**WELWYN HATFIELD BOROUGH COUNCIL  
EXECUTIVE DIRECTOR - PLANNING, PUBLIC PROTECTION AND GOVERNANCE**

**DELEGATED APPLICATION**

**Application No:** 6/2018/0825/MAJ  
**Location:** 37 Broadwater Road Welwyn Garden City AL7 3AX  
**Proposal:** Construction of new build of 22 x 2 bedroom and 2 x 3 bedroom residential apartments with balconies and roof garden, layout of 26 car parking spaces, cycle parking, refuse store, internal access routes, landscaping and supporting infrastructure  
**Officer:** Mr Michael Robinson

**Recommendation:** Refused

Drawing Stage: **PLANNING**
 Project Title: **PROPOSED SITE PLAN**
 Project Title: **PROPOSED SITE PLAN**
 Project Title: **PROPOSED SITE PLAN**

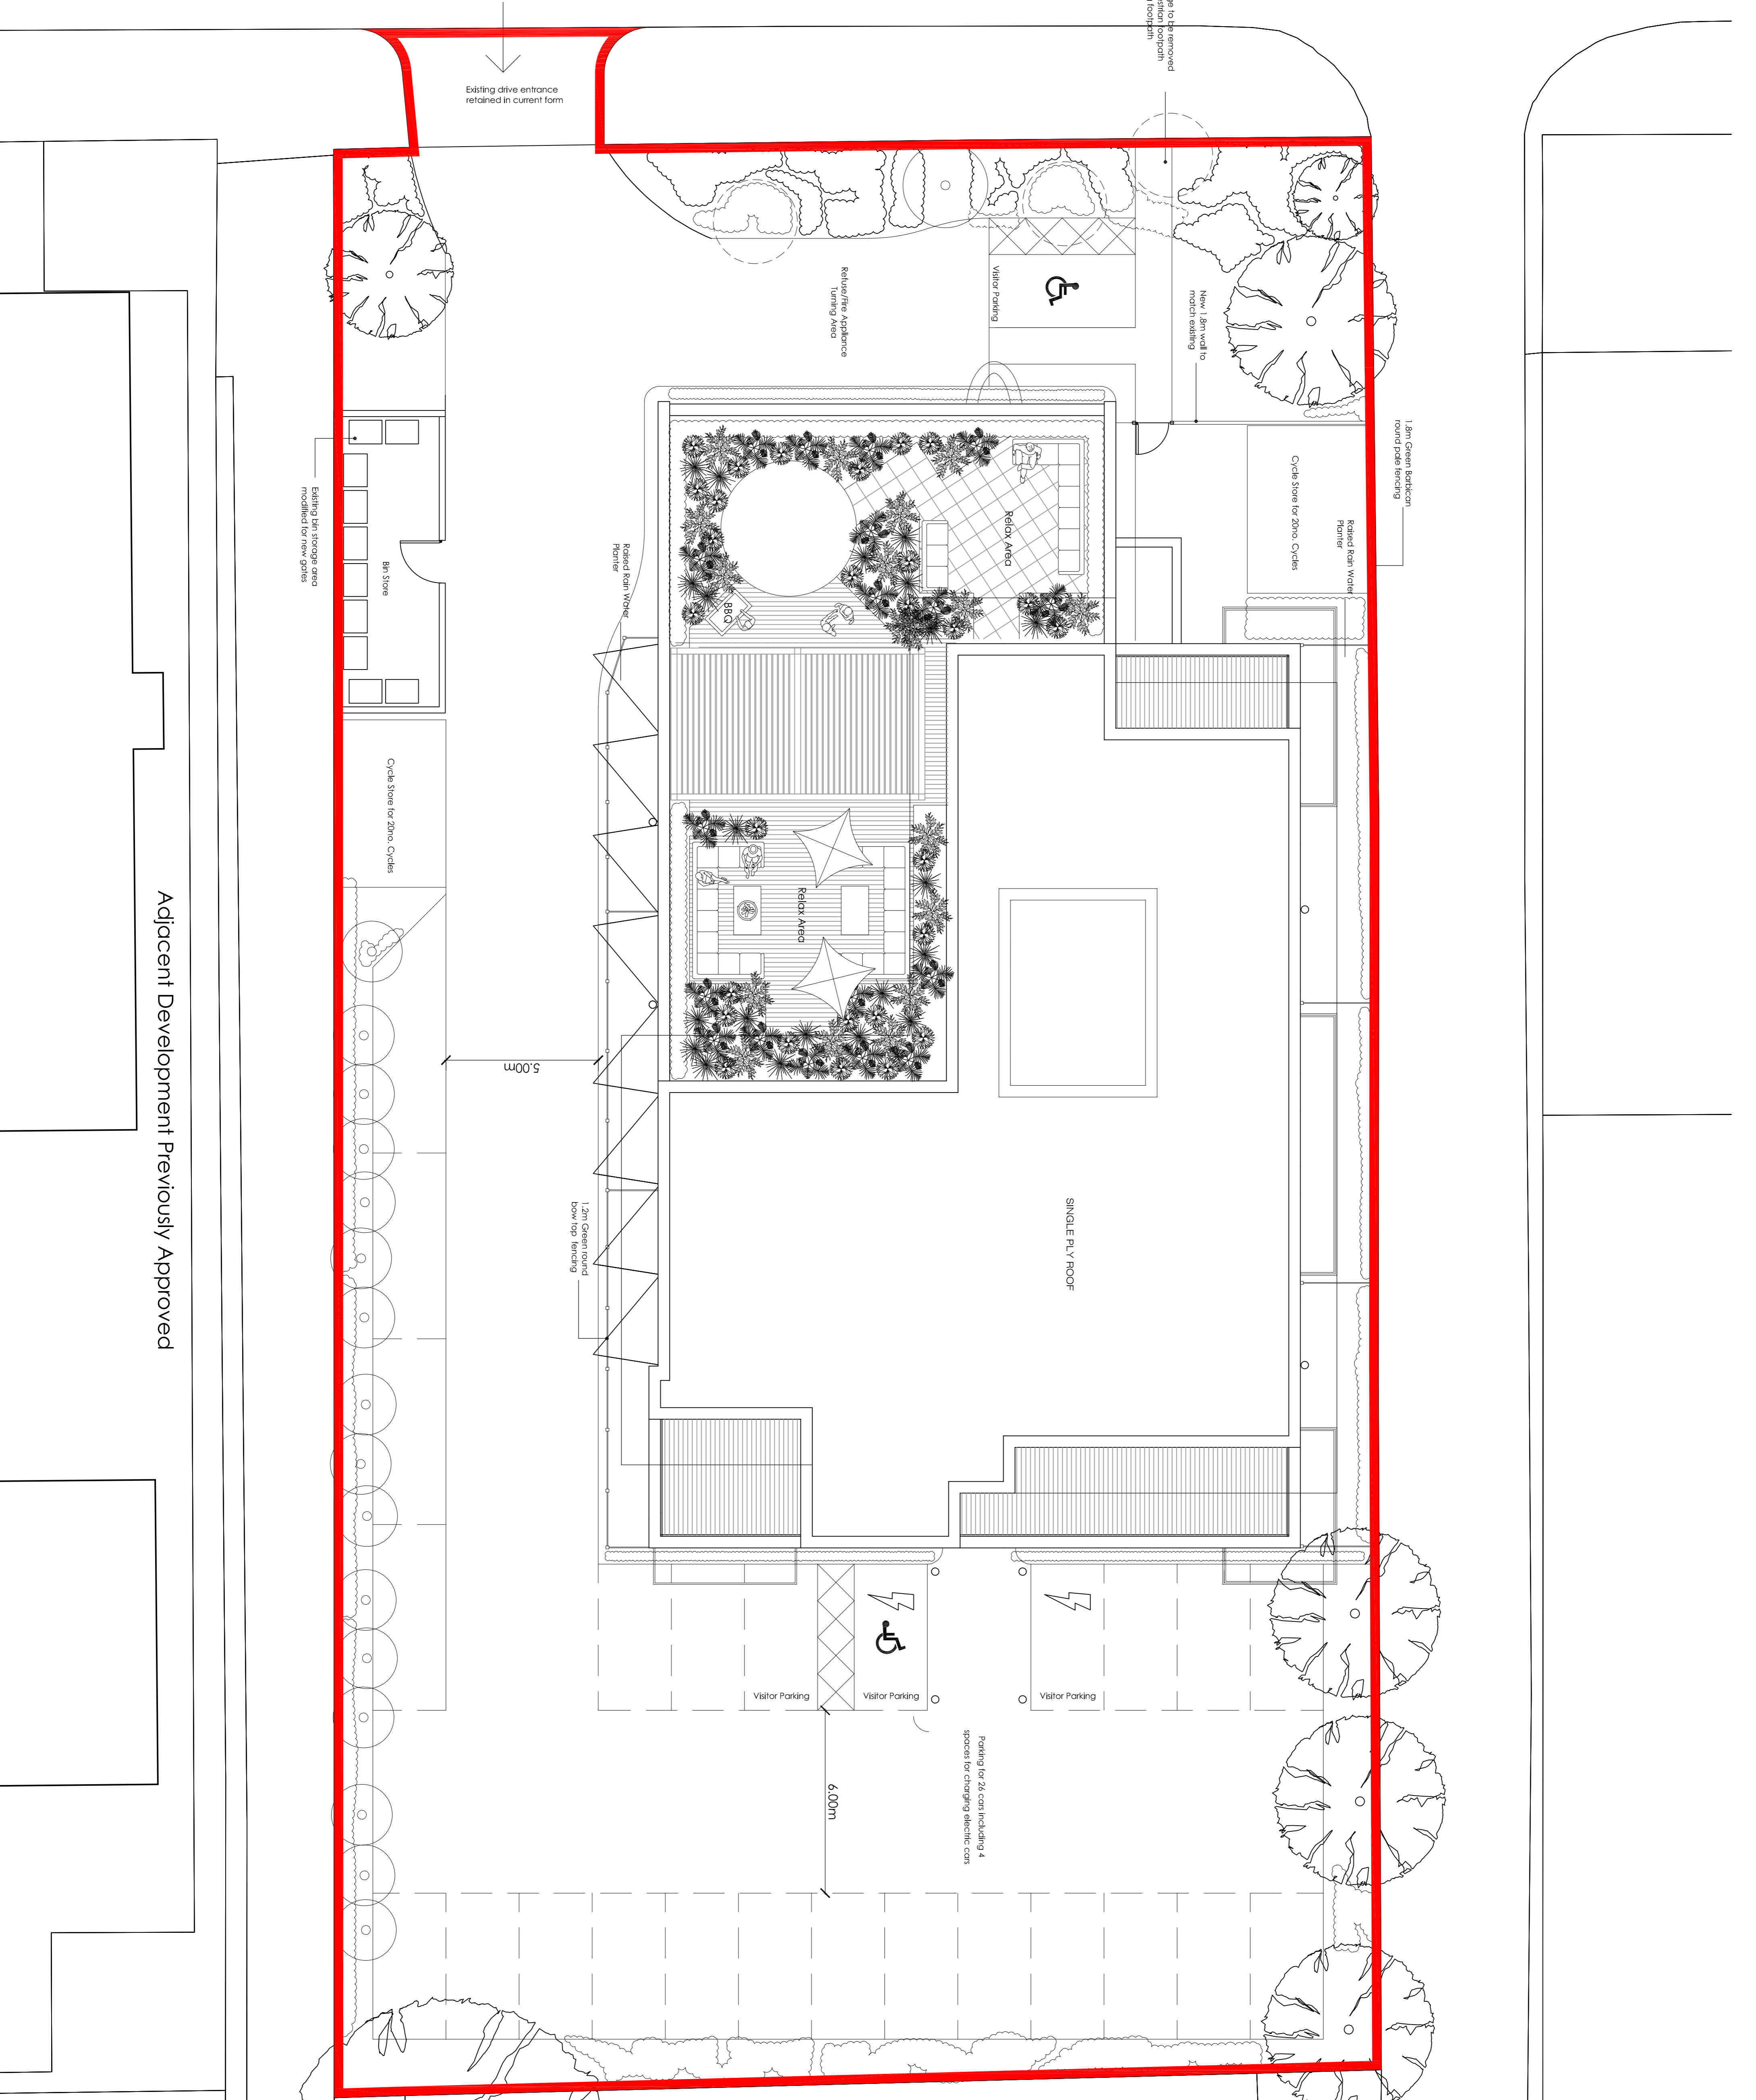
HCC observe that the current proposed plan for this application (Drawing 1583 203 rev A) appears materially unchanged to that considered as part of the above Variation.

The applicant confirms that no new or amended vehicle access be provided for the development, and instead uses the existing double width crossover to Broadwater Road. Whilst the site has been vacant for sometime, a review of the previous five years data for collision data identifies no record of the access being unsafe. Visibility from the access is suitable for posted speeds.

The current application does not provide details in respect of servicing / emergency vehicle access. However, noting that the layout is materially unchanged to previous schemes, I am minded that tracking has been submitted as part of the 2016 application (6/2016/2497/MAJ) and found acceptable to the HA. The turning head enables vehicles (including larger vehicles) to enter and leave in forward gear and ensures the development is appropriate in terms of access from a Principle A road.

Areas for car parking are shown with adequate clear depth behind all parking spaces to ensure that they may be accessed without undue difficulty. 1 space is provided in accordance with the recommendations of BS8300 : Design of buildings and their approaches to meet the needs of disabled persons : Code of Practice, and therefore accessible for persons in a wheelchair and it is noted that the scheme includes provision for charging of Electric Vehicles (EV). This ensures that the development provides for future technology for transport, however from plan 1583 203 rev A, there is a discrepancy between the described 4 off bays providing charging, and the 2 shown. I note that the Fire Authority have not presented (to earlier applications) concerns or a requirement for addition space.

Internal routes provide 5m carriageway width, and enable vehicles to pass clear of each other. Separate pedestrian access is provided.

Applicant provides secure cycle parking in two locations (totalling provision for 40 bicycles) which is welcomed as it will promote and enable such modes of travel.
